DECISION DELEGATED TO HEAD OF PLANNING

Application No: H16-0878-21 **Applicant:** Mr & Mrs Holmes
Proposal: First Floor Extension & Alterations
Location: 16 Edinburgh Drive Spalding
Terminal Date: 5th November 2021

A	ALTERATIONS TO GABLE AND PART OF FLAT ROOF REINSTALLED	OCT 21

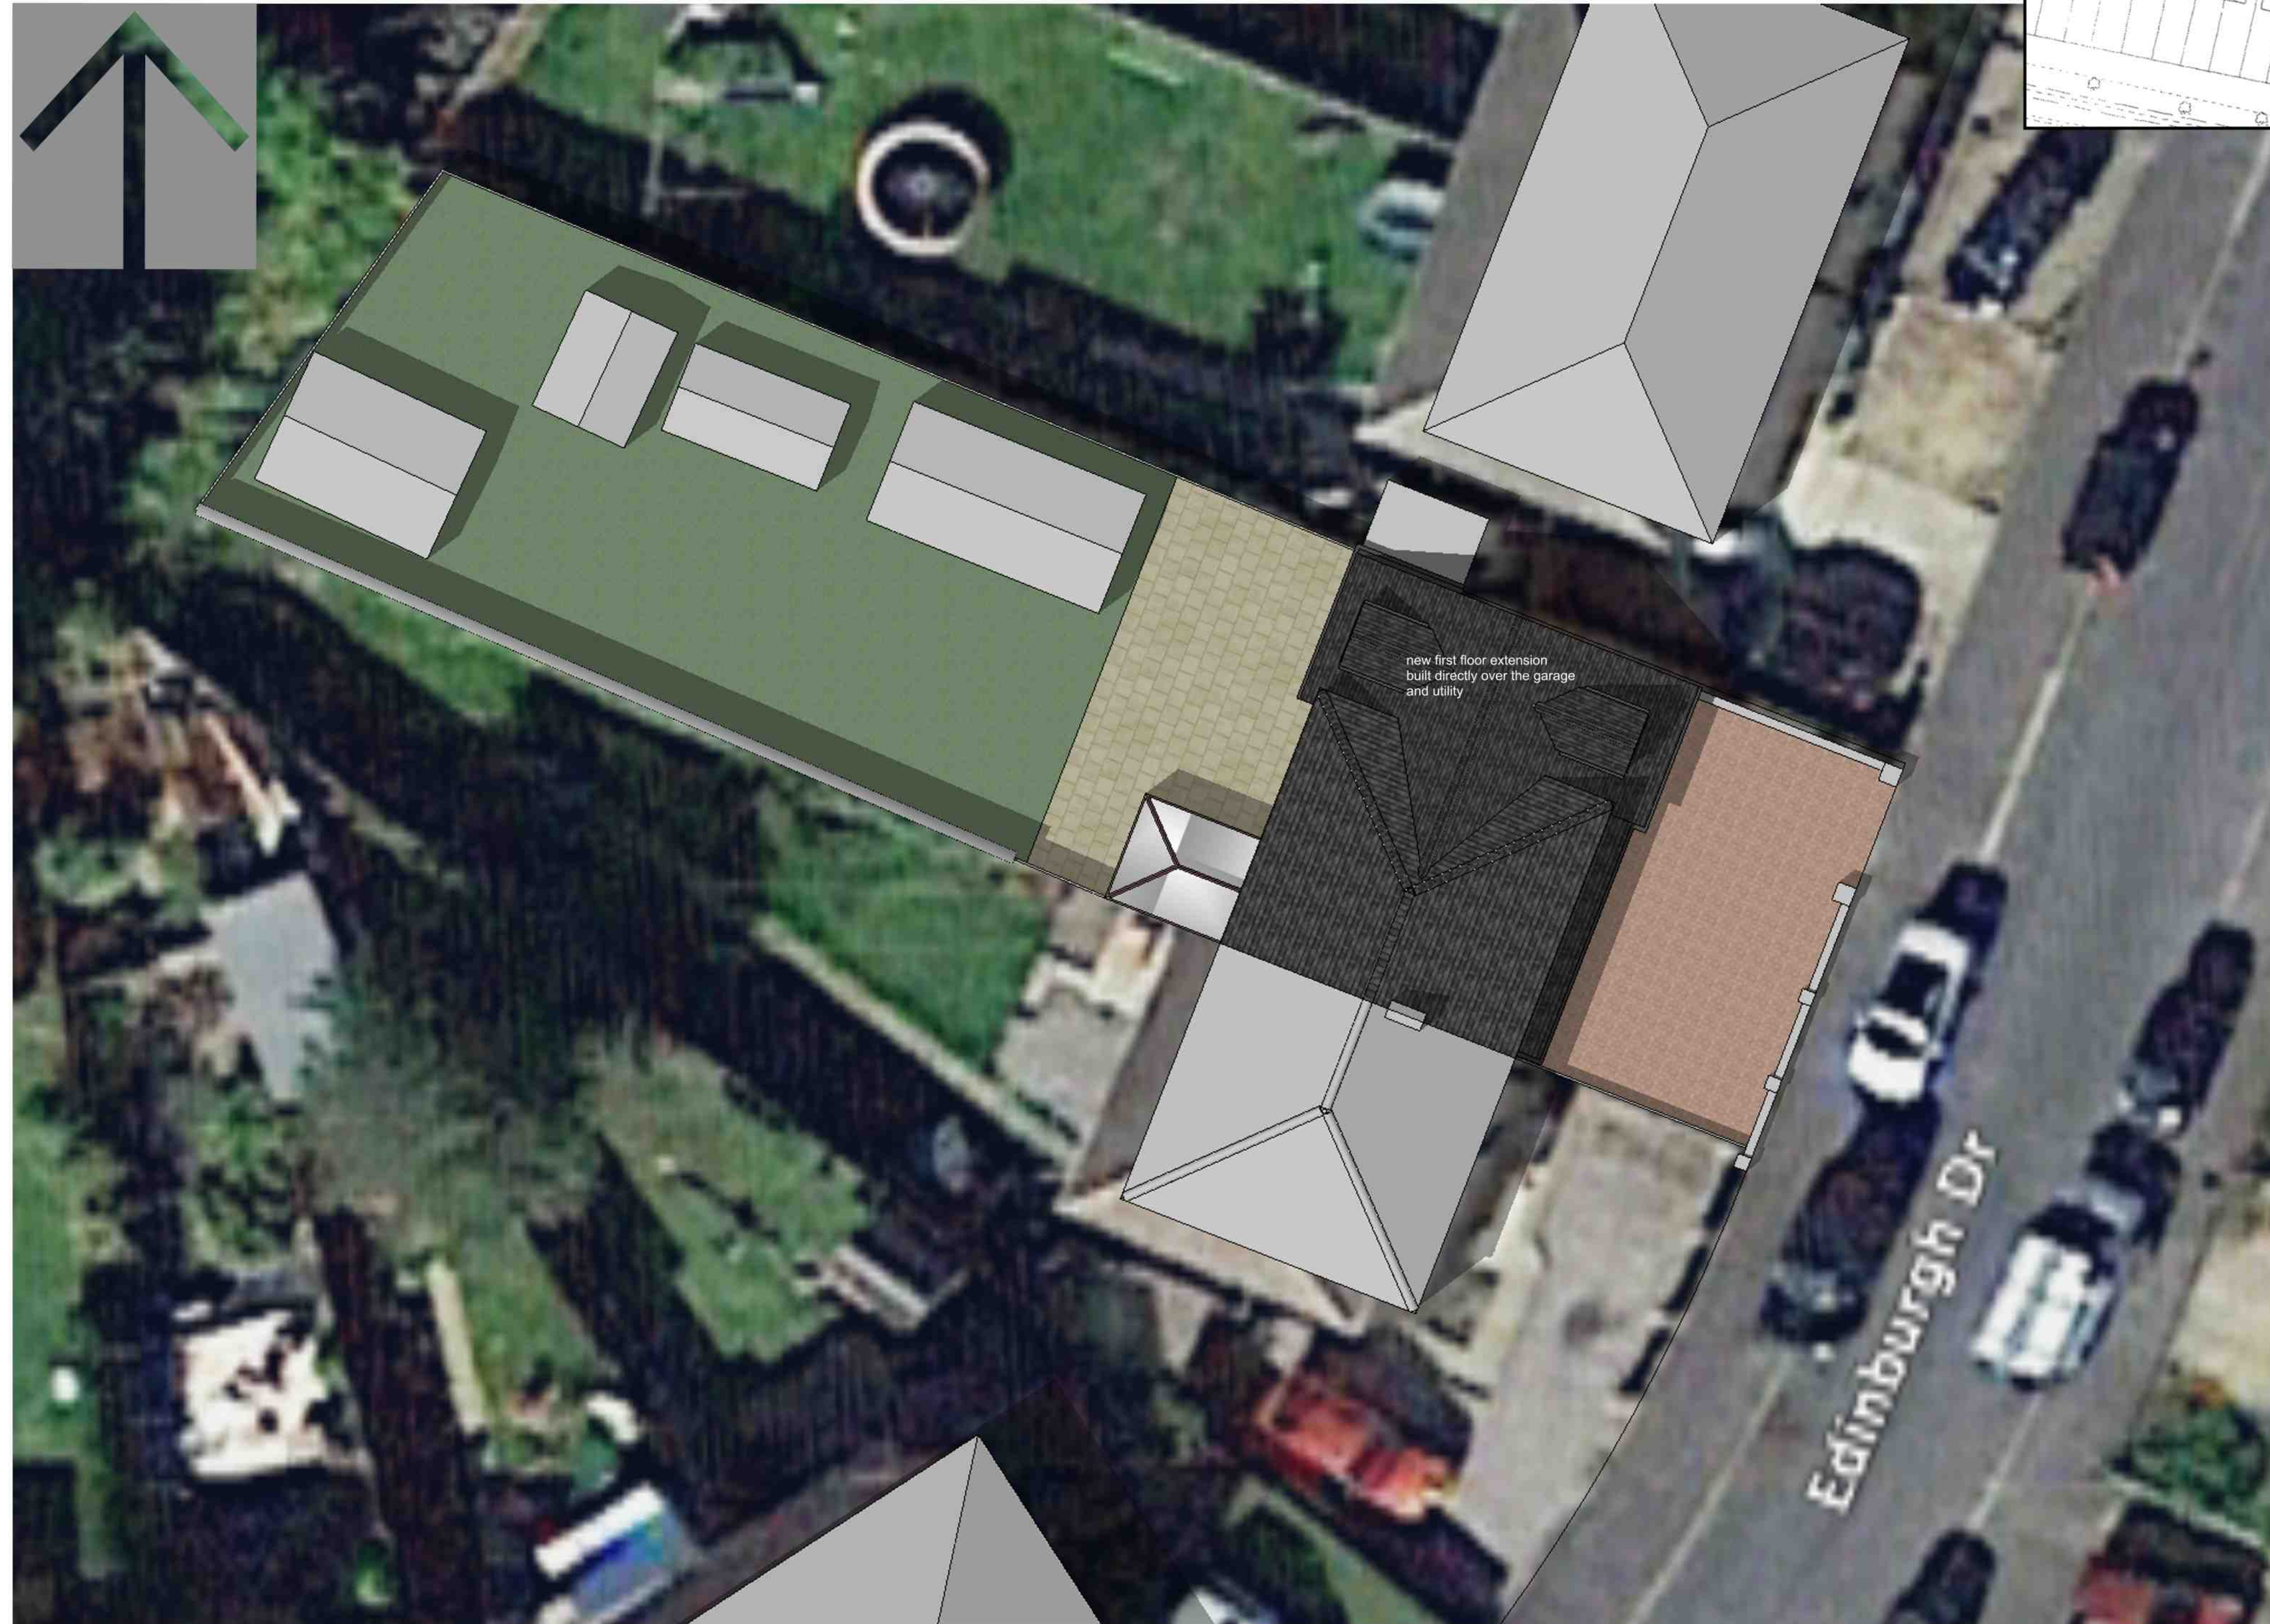
Concern has also been raised regarding the overhanging of fascias and guttering on the northern side. The existing overhang was constructed before it was owned by the existing owner. It is confirmed by the agent that the proposal will keep a small piece of the remaining flat roof and the plans have been revised in order that the proposed fascias to the first floor extension will be situated within the boundary of 16 Edinburgh Drive, and therefore no further encroachment will occur from the proposal.

PROPOSED PLANS
AND ELEVATIONS

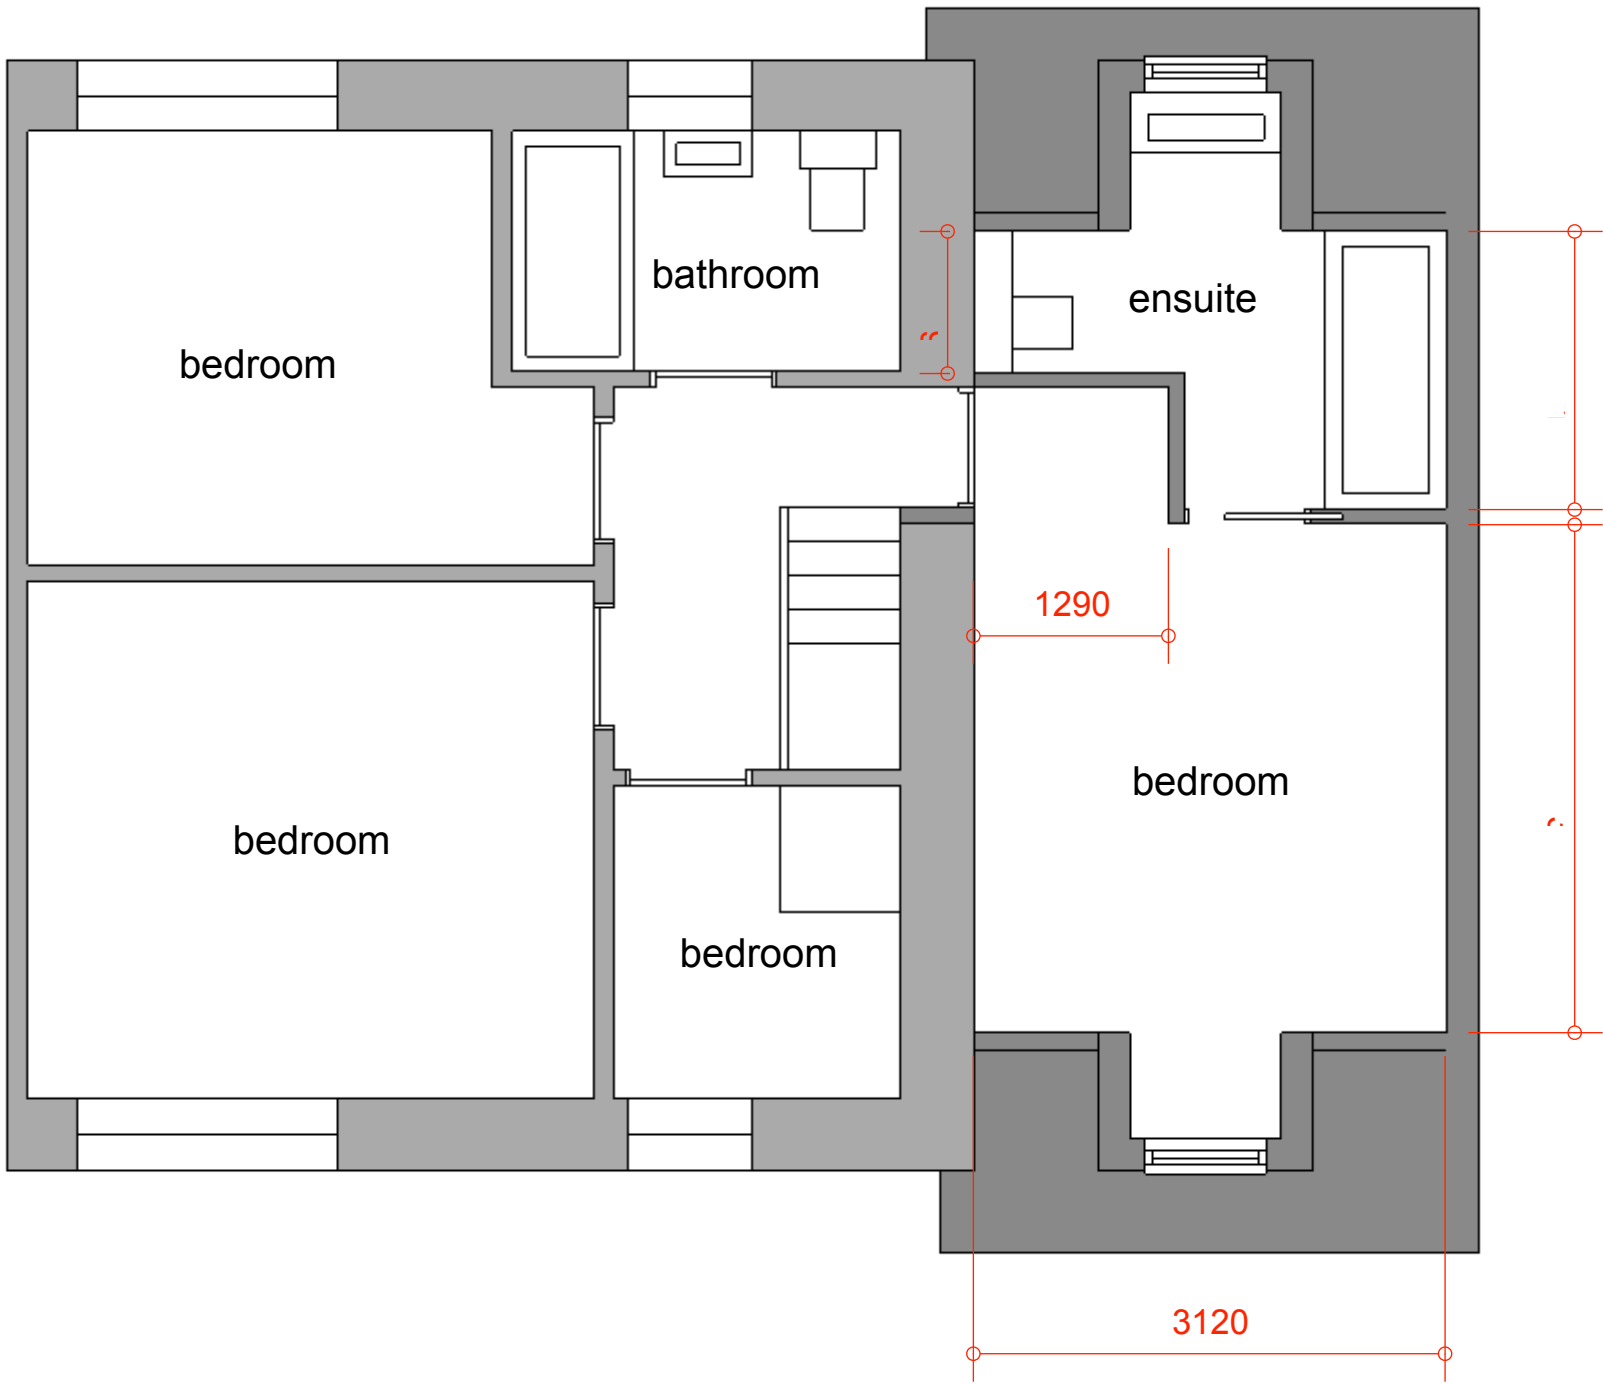
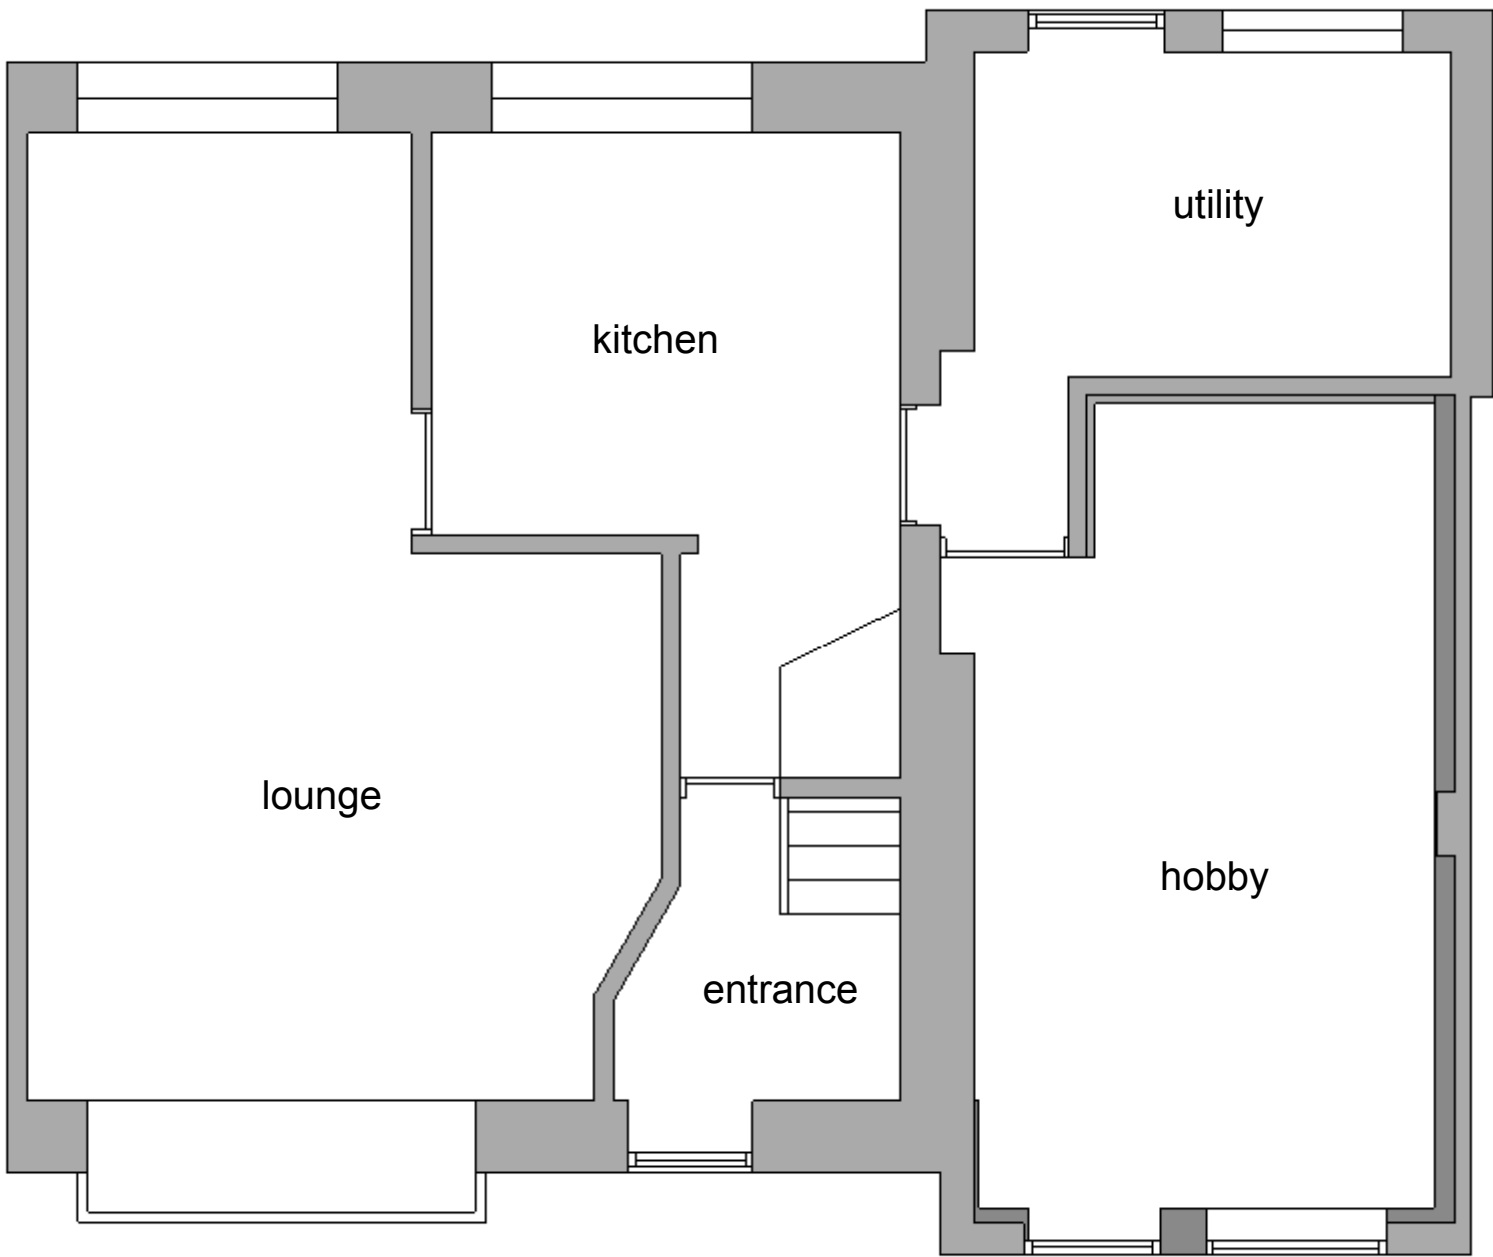
The proposed extension will extend above the existing garage and utility room. The extension will protrude from the northern side elevation by approx. 3.3m and be 8.3m in depth (maximum taken at the eaves). The ridge height of the extension would be lower than the host dwelling. Having regard to the existing dimensions of the house, the proposed first floor extension is acceptable in terms of scale, mass and bulk. Concern has been raised regarding the extension restricting the openness between properties, however the footprint of the building would not be enlarged and a separation distance between dwellings of approx. 3.2m is satisfactory and in keeping with other properties on Edinburgh Drive.

The external materials consist of brown upvc windows, concrete roof tiles and facing brickwork to match existing. In addition, dark fake timber vertical cladding will be added to part of the ground floor of the extension, the former windows and first floor side elevation. Concerns have been raised regarding the dark timber cladding being out of keeping with the character of the surrounding area. However, it can be seen that the dwellings along this road vary in brick type and a dark timber effect cladding would not be unduly obtrusive given the proportion of the dwelling that would be covered.

The proposed windows are to the front and rear elevations of the first floor extension. Concern has been raised regarding overlooking from the rear facing window, however this window would be to an en-suite bathroom and it has been confirmed it would be obscure glazed. The windows to the front are tantamount to a typical frontage relationship. There would therefore not be a material overlooking impact from the proposal.

The side elevation first floor windows to the neighbouring property are for a landing and bathroom. To the ground floor of the neighbouring side elevation is a back door with a small window through to the kitchen. These spaces are not deemed 'habitable rooms' in planning terms and therefore it is not considered that there would be a material overbearing or overshadowing impact such that would justify refusing the application. Impact on views is a consideration but one which carries very limited weight in the overall planning balance, particularly where non-habitable rooms are concerned.
